Proposed demolition of existing structures and construction of 1 no. Dwelling. at Little Penton, Onslow Green, Barnston, CM6 3PP

UTT/21/1497/FUL

Non-Material Amendment(s) Sought

1. Removal of chimney.
2. Removal of rear central window.
3. Addition of canopy over principal entrance
4. Addition of 2x Heritage conservation roof lights

North East Elevation
1:50

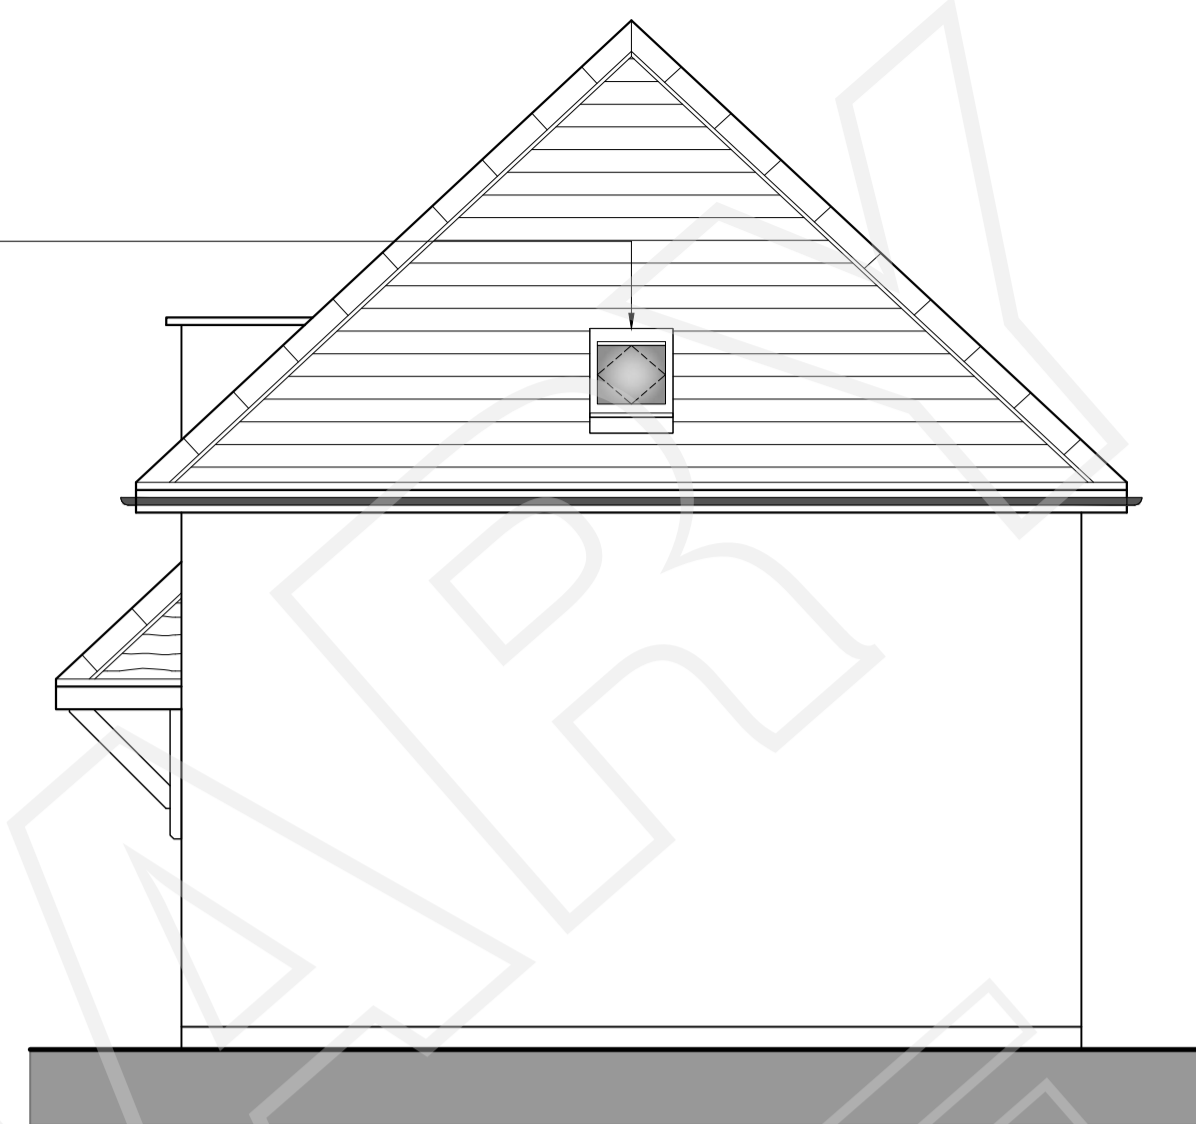
1. Use of solid fuel burning heat appliances has become less compatible with achieving compliance of Approved document L: Conservation of fuel and power and must be removed.
2. Reduction of glazing on south façade to achieve compliance with Requirement O1: Overheating mitigation calculation approach which current approval does not achieve.
3. As required by Category 2: Document M specified in condition 7 of the existing approval.
4. Addition of free ventilation area to achieve a pass for Requirement O1: Overheating mitigation calculation approach which current approval does not achieve.
